**KIRKLEES METROPOLITAN COUNCIL  
INVESTMENT & REGENERATION SERVICE**

**DELEGATED DECISION TO DETERMINE PLANNING APPLICATIONS**

Reference No:	<b>2025/62/92028/E</b>
Site Address:	13, Gardens Road, Ravensthorpe, Dewsbury, WF13 3HQ
Description:	Erection of single storey front and single and two storey rear extensions and rear dormer
Recommending Officer:	Jennifer Booth

## **OFFICER REPORT**

PROPOSED REAR ELEVATION 1:100

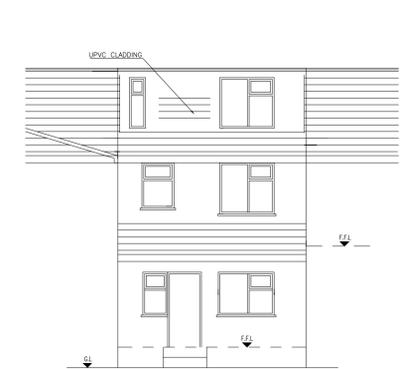
The proposed single- and two-storey rear extensions would occupy a substantial proportion of the rear garden and, due to their overall scale and flat-roofed form, would not represent especially high-quality design. While the massing is appreciable and the roof profile is somewhat utilitarian in appearance, the use of matching external materials would help the development integrate more effectively with the host dwelling. In addition, the surrounding area contains a varied mix of rear extensions of differing scales and designs, which reduces the overall impact on visual amenity. On balance, although the scheme is not exemplary in design terms, it is not considered to result in sufficient harm to visual amenity to justify refusal.

The proposed rear dormer would not represent particularly high-quality design, with a functional appearance that provides limited enhancement to the character of the dwelling. The inclusion of horizontal uPVC cladding further emphasises its utilitarian form; however, this impact can be mitigated through the use of a grey finish secured by condition, which would help to ensure a more subdued and complementary appearance. In addition, the applicant benefits from a permitted-development fallback that could allow for a dormer of a similar size / scale to be constructed to the rear roof slope in any event.

The first-floor element is designed with a lean to roof, which would tie into the existing roof / proposed dormer. This is considered to be a design which to some extent reduces the overall scale and massing resulting from the proposal and would, to some degree, reduce the level of overbearing resulting from the development.

It is clear the proposal would cut a 45° line when taken from the centre of the cill of windows in the rear of no.13. Weight is afforded, in this case, the fact that the ground floor element can be constructed in any event, with this element causing the greatest extent of harm in terms of being oppressive to the outlook from the rear of no.11.

Conditions can ensure that the use of materials of construction to the extensions match those used in the construction of the host property and that the colour finish of the dormer roof is dark grey. This will assist in ensuring the development suitably integrates with the host property.

3. The external walls and roofing materials of the extension hereby approved shall in all respects match those used in the construction of the existing building. The dormer hereby approved shall be of a dark grey colour finish. The development shall be constructed in accordance with the materials of construction and colour finish approved by this condition which shall be completed prior to the development being brought into use and retained thereafter.

The front extension as proposed is modest in terms of scale and would allow the main house to remain the dominant feature of the site. The materials proposed include the use of brick and tiles to match the host property.

There is already a single storey element to the front of the host property and the neighbouring dwelling (no.15). The proposal would not significantly increase the scale and massing or alter the design of the existing front single storey element and would not be significantly larger than that of the adjoining

The front extension is of a limited scale and would result in no significant increase in relation to overlooking, overshadowing or overbearing. Whilst the side elevation is along the front shared boundary, the projection (being 1.5m) is such that the proposal would not lead to a significant impact in terms of light or constitute an unduly oppressive / overbearing addition.

PROPOSED SIDE ELEVATION 1:100

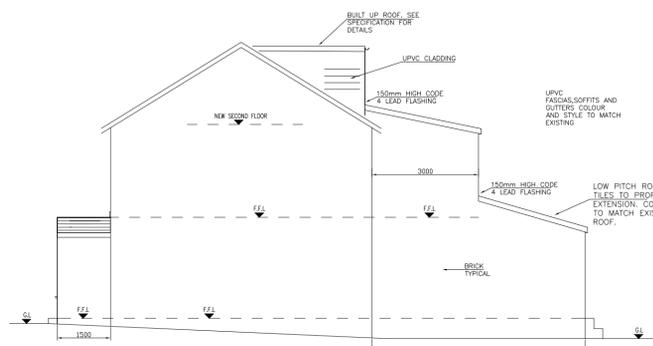
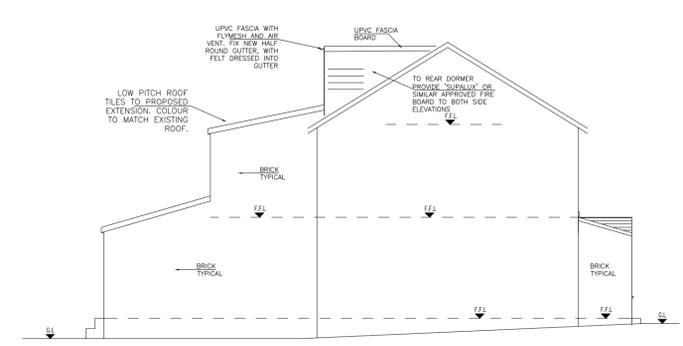
The proposed rear extension would be constructed along the shared boundary. The ground-floor element has already been established as permitted development with prior approval not being required (and the appropriate prior approval process being undertaken – detailed in the planning history section of this report).
